Report following a request for further information or negotiation

REF NO: AW/215/14/A

LOCATION: Ship Inn
Aldwick Street
Bognor Regis

PROPOSAL: 2No. internally illuminated fascia signs to front and west side elevations, 1No. externally illuminated fascia sign to east side elevation and 1No. externally illuminated projecting signs to front elevation.

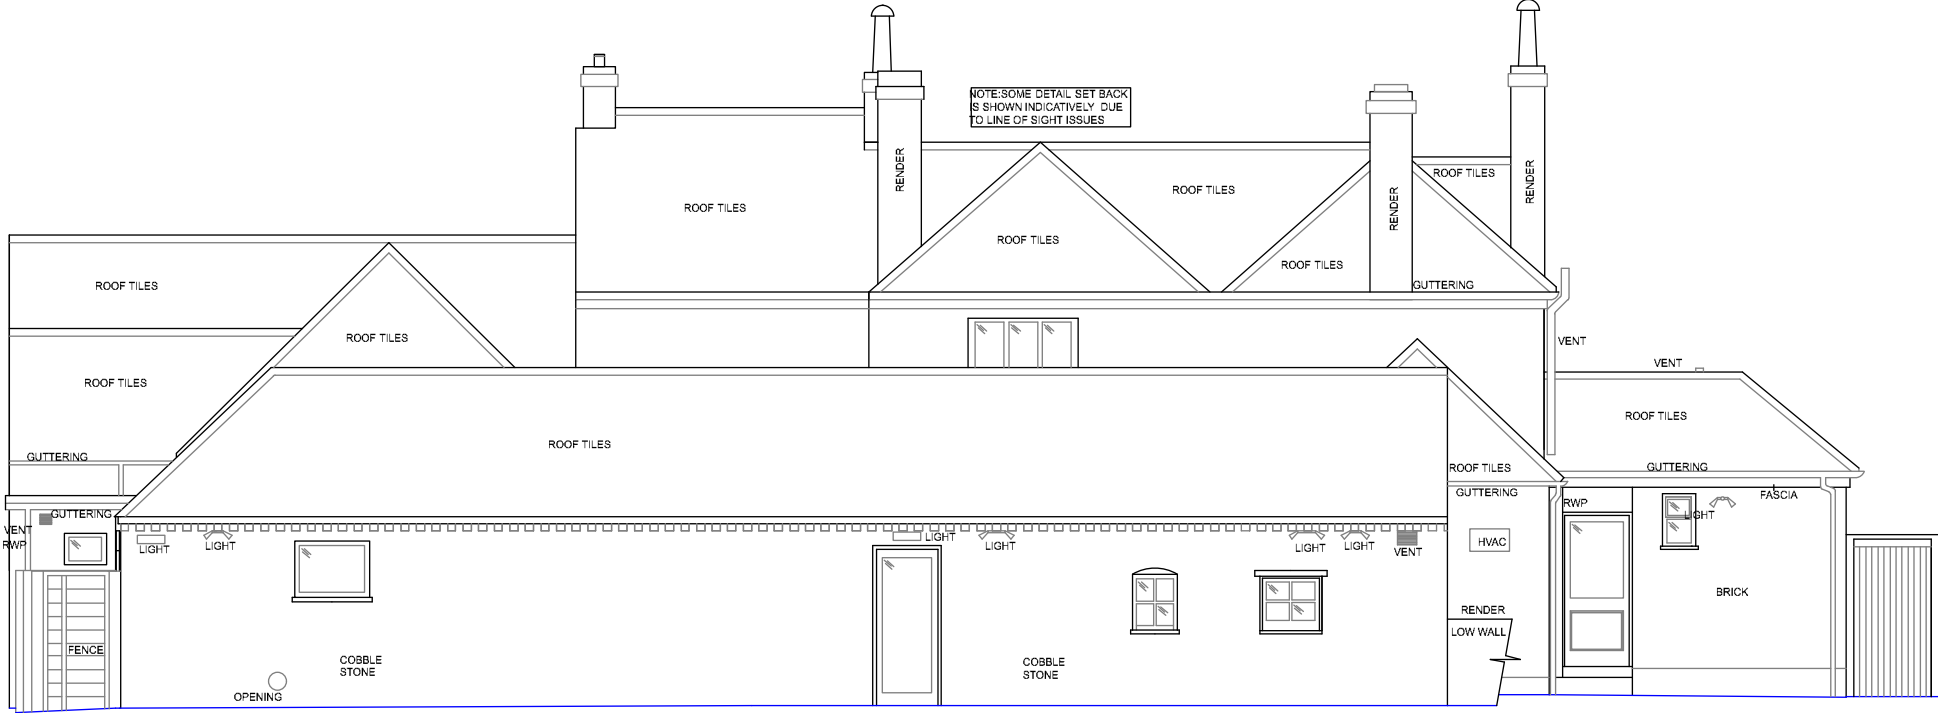
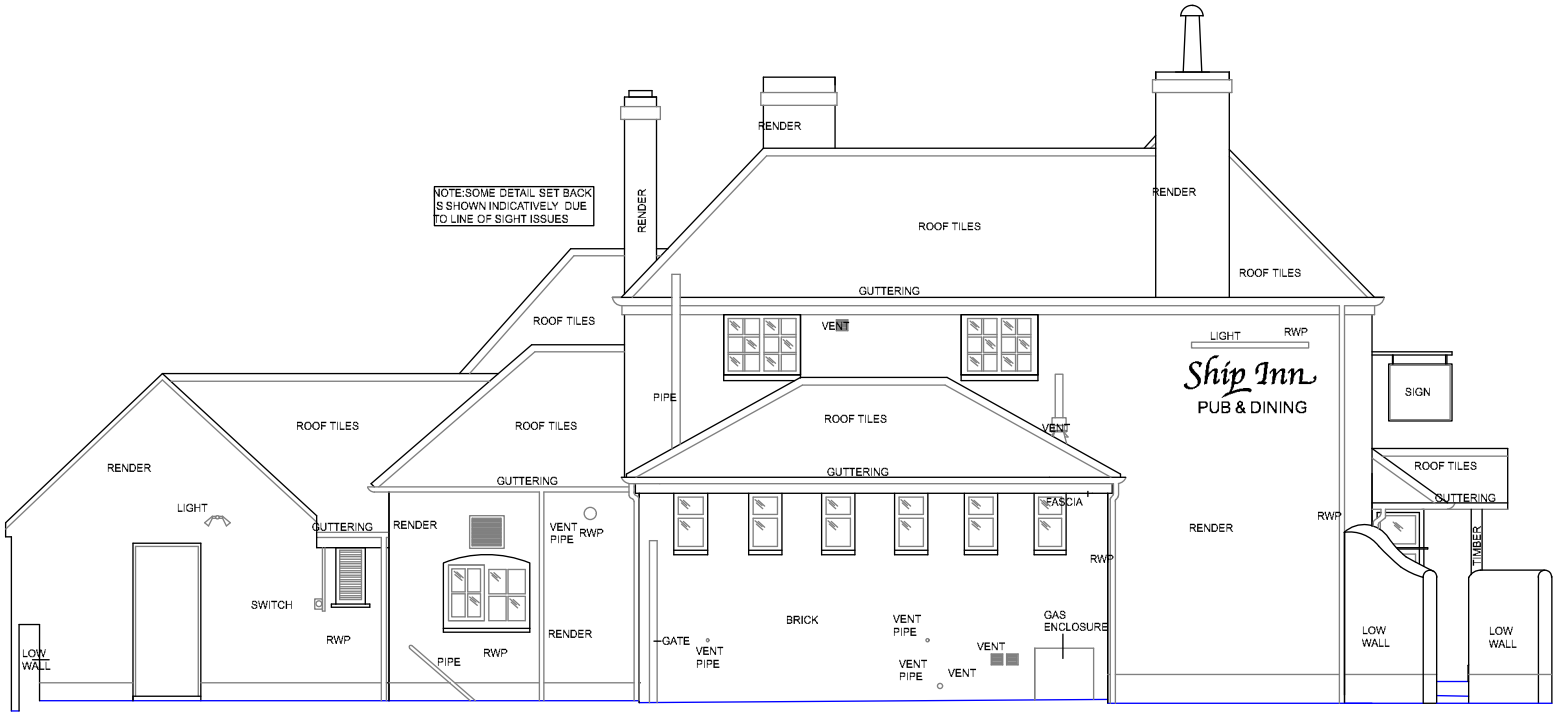
It is considered that there is an excessive amount of signage on the property. The amount, location and size of advert/signs create a cluttered effect specifically sign 2 and 6 (bus stop signs). Are these required as they repeat most of the text in the other signs. Sign 5 this is a large sign. Could it be reduced to match the width of the window/door?

The removal of one of the hanging signs is supported, but I still have strong concerns regarding the design of sign 5. It is still considered that this sign is excessive and should be reduced in size. The majority of the elevation will be hidden from view until relatively close to the building; this will limit the impact that such a sign will have on the passing public.

"Unfortunately, it is not possible to stack the 7am-11pm every day lettering underneath the Morrison's M Local lettering and therefore it would be difficult to reduce the extent of the fascia sign above the entrance (sign 5).

Although the Council's Conservation Officer still has reservations about Sign 5, it is clear that the applicants will not amend this and it is not considered that the impact of this on amenity is significant enough to warrant a refusal on these grounds. As noted above, the building was previously in use as a public house and had its own illuminated signage. Whilst the proposed signage is more noticeable than the existing, the previous use is an important material consideration and furthermore, part of the reason why the signage is more noticeable is that Morrison's have their own distinct green and yellow brand (which by its nature is brighter than black on cream).
